City of Portland, Maine - Building or Use Permit Application
 389 Congress Street, 04101 Tel: (207) 874-8703, Fax: (207) 874-8716

Permit No: 05-1707	Issue Date:	CBL: 178 G026001
------------------------------	--------------------	----------------------------

Past Use: Single Family	Proposed Use: Single Family with in-law apartment over the garage. Approved by Zoning Board of Appeals on 11/17/05.	Permit Fee: \$276.00	Cost of Work: \$20,000.00	CEO District: 3
		FIRE DEPT: <input type="checkbox"/> Approved <input type="checkbox"/> Denied	INSPECTION: Use Group: Type

BUILDING PERMIT
02 0928

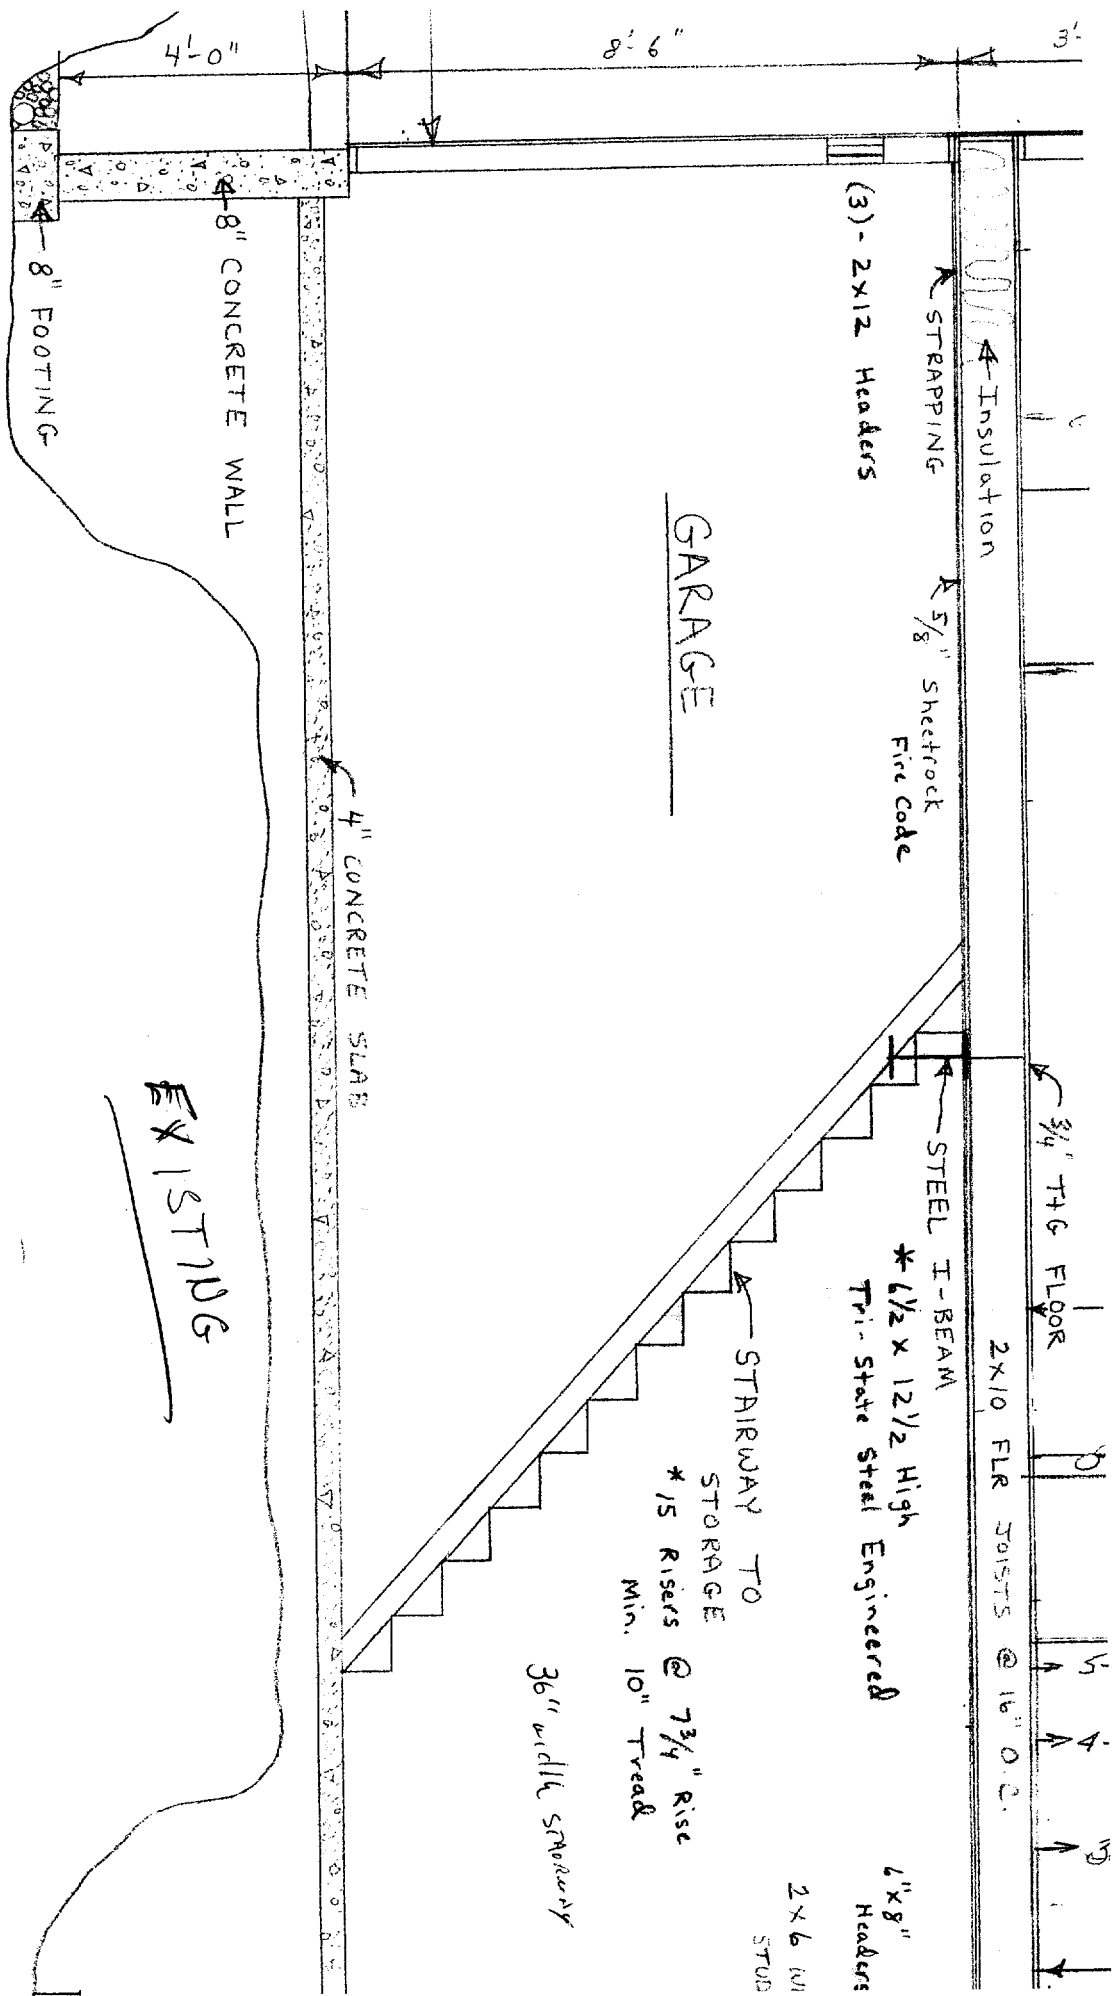
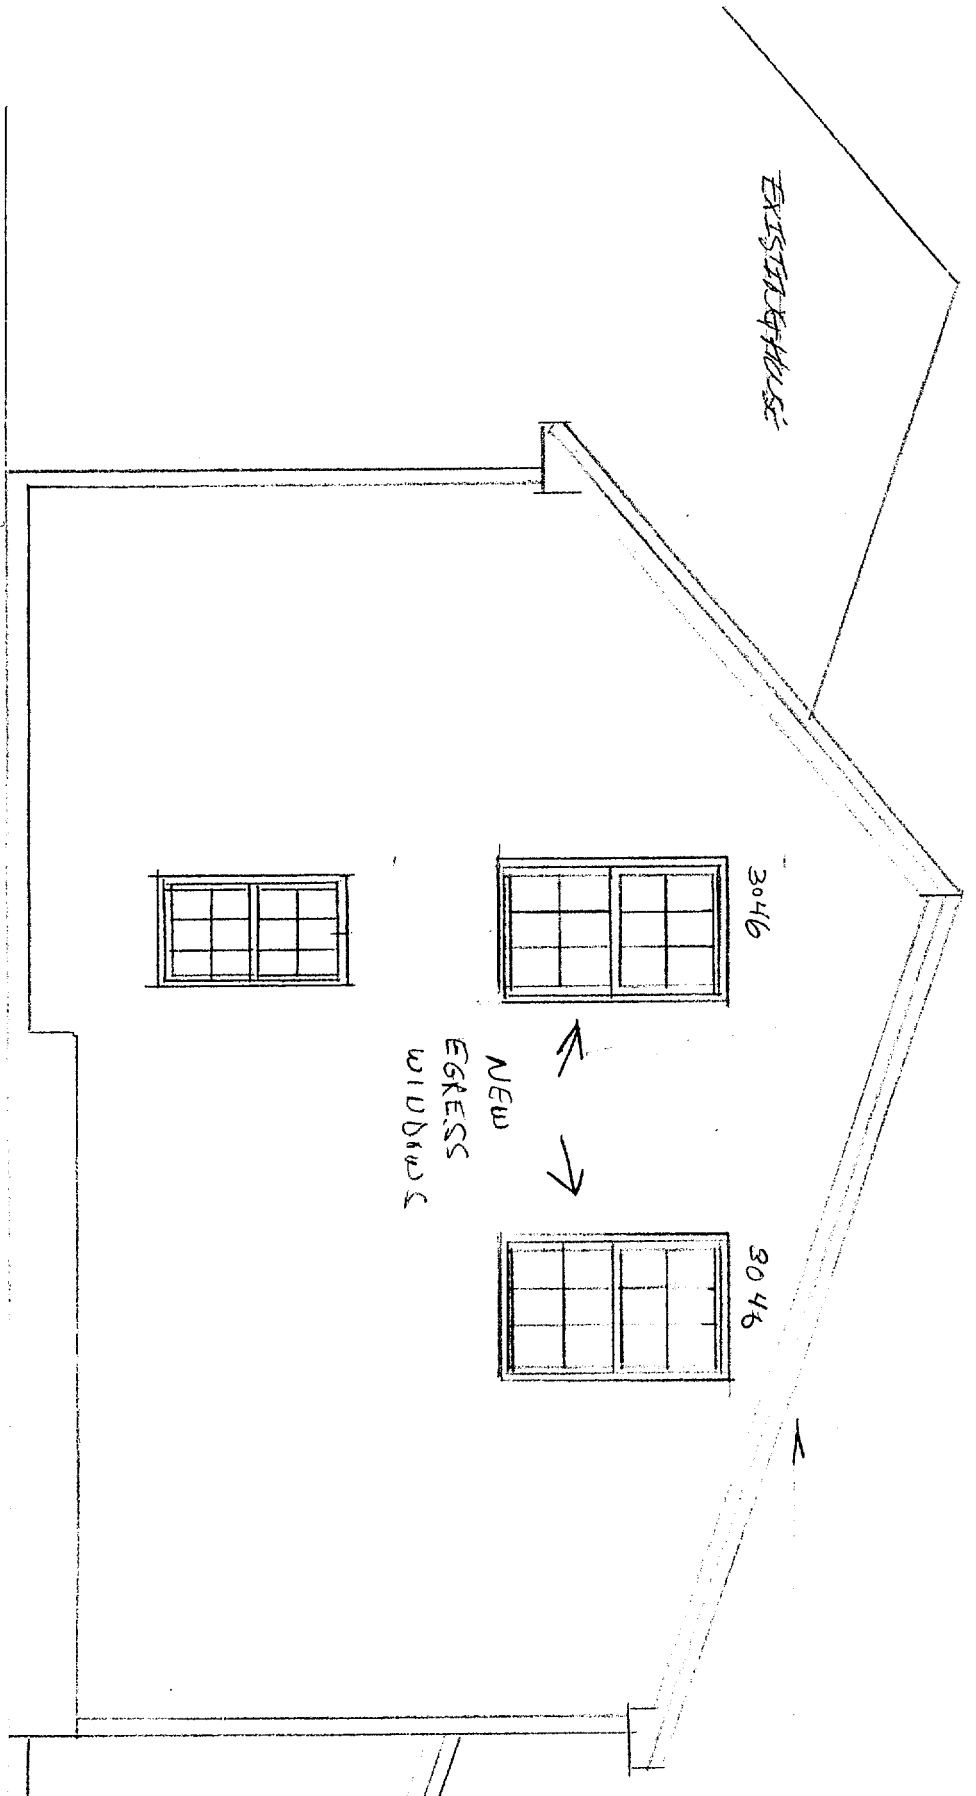
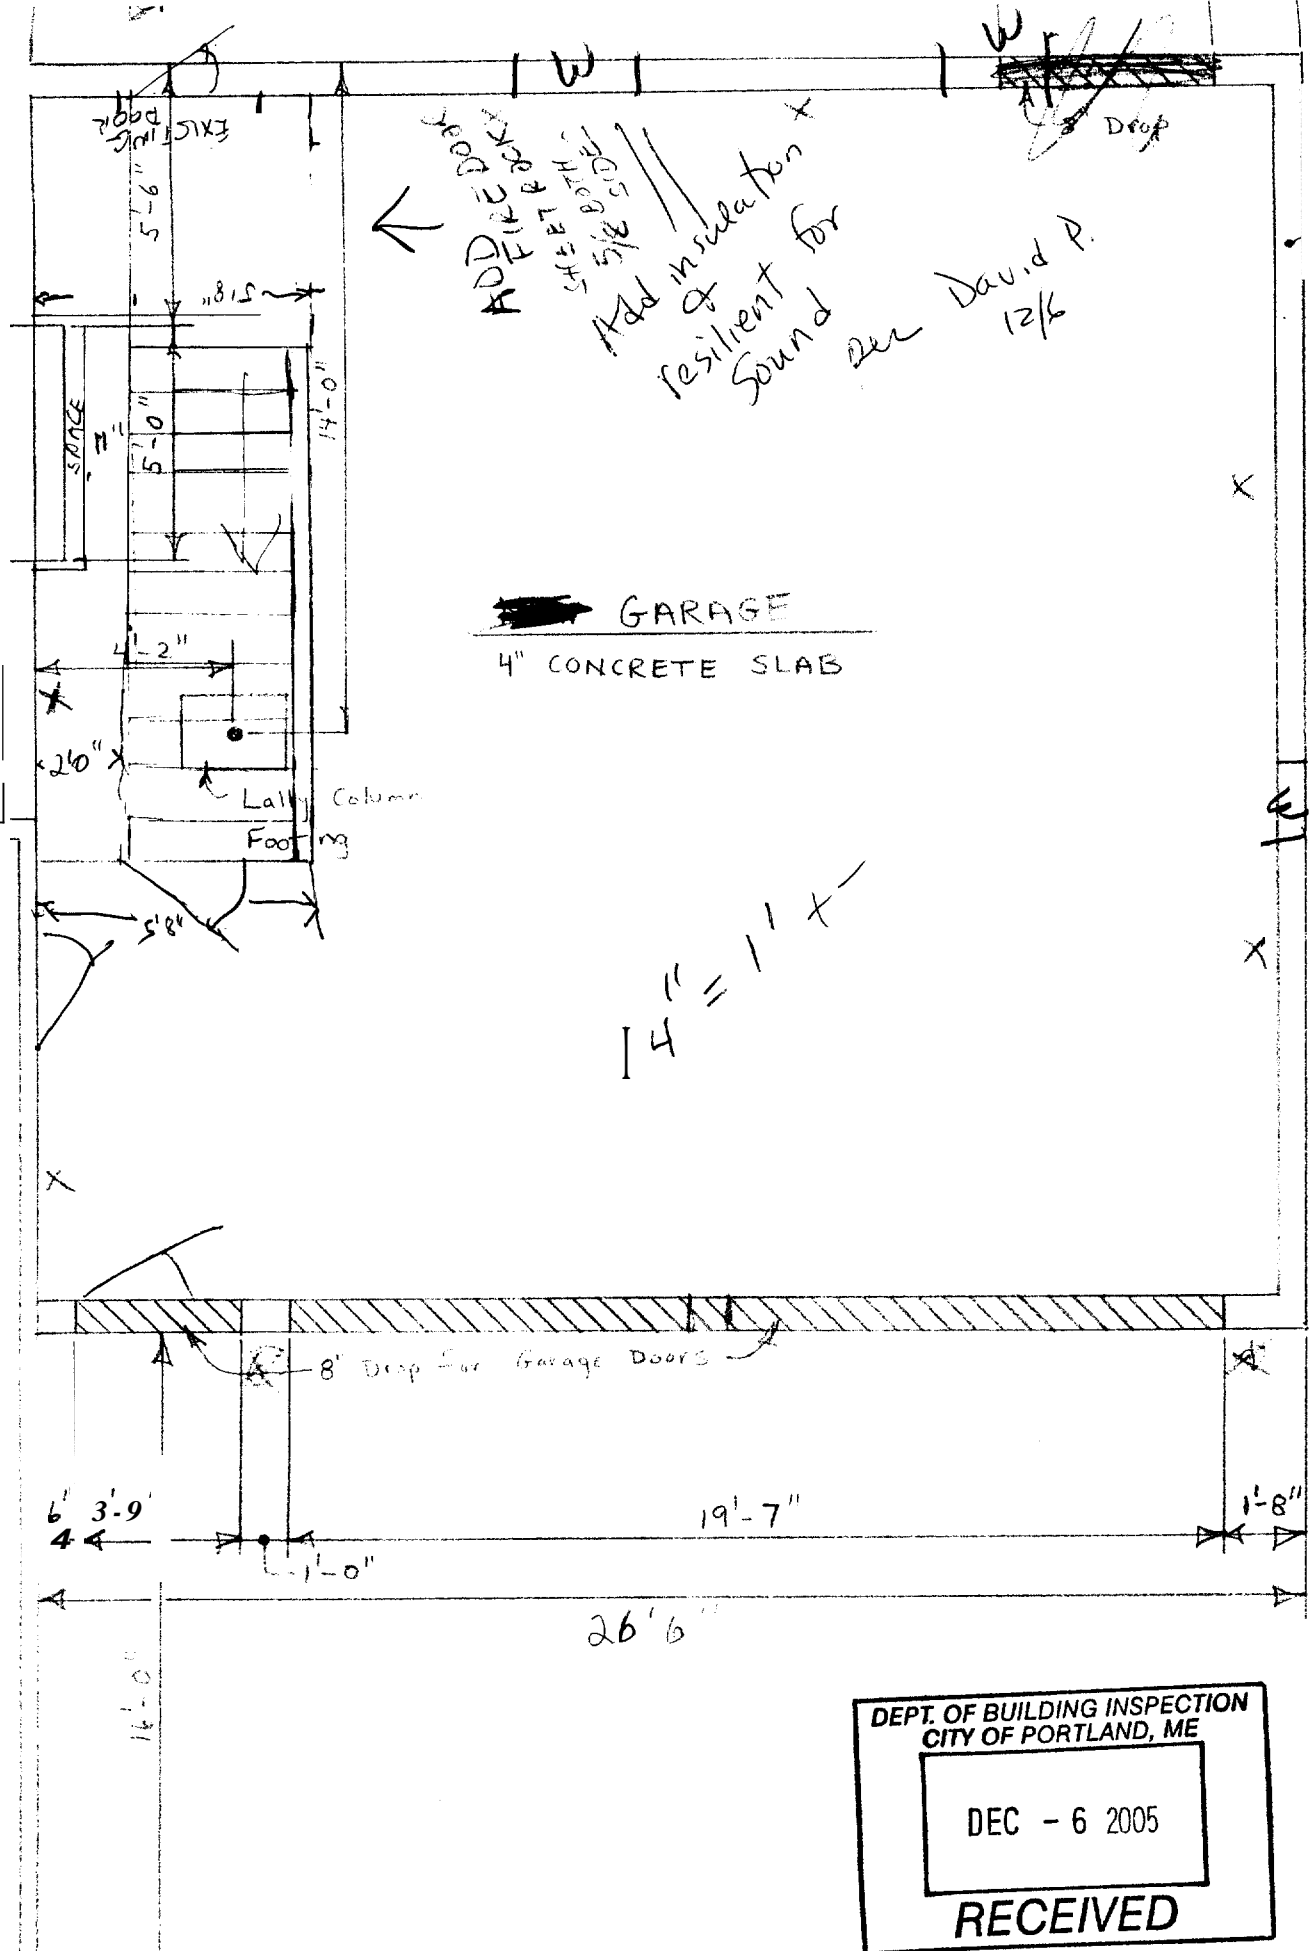
Dept: Zoning	Status: Approved with Conditions	Reviewer: Ann Machado	Approval Date: 11/23/2005
Note:			Ok to Issue: <input checked="" type="checkbox"/>
1) This permit is approved with the understanding that the conditions stated in section 14-88 (a) for conditional use appeal are maintained for the life of the unit.			
Dept: Building	Status: Approved with Conditions	Reviewer: Jeanine Bourke	Approval Date: 12/06/2005
Note:			Ok to Issue: <input checked="" type="checkbox"/>
1) Permit approved based on the plans submitted and reviewed w/owner/contractor, with additional information as agreed on and as noted on plans.			
2) Must submit garage floor plan with the fire wall & door at issuance of permit			
3) Separate permits are required for any electrical, plumbing, or heating.

Comments:
12/06/2005-GG: received granted site exemption. /gg
12/06/2005-jmb: Spoke to David P. About code for bathroom height, fire separations & smokes. He will bring in a garage plan showing a fire wall & door today.
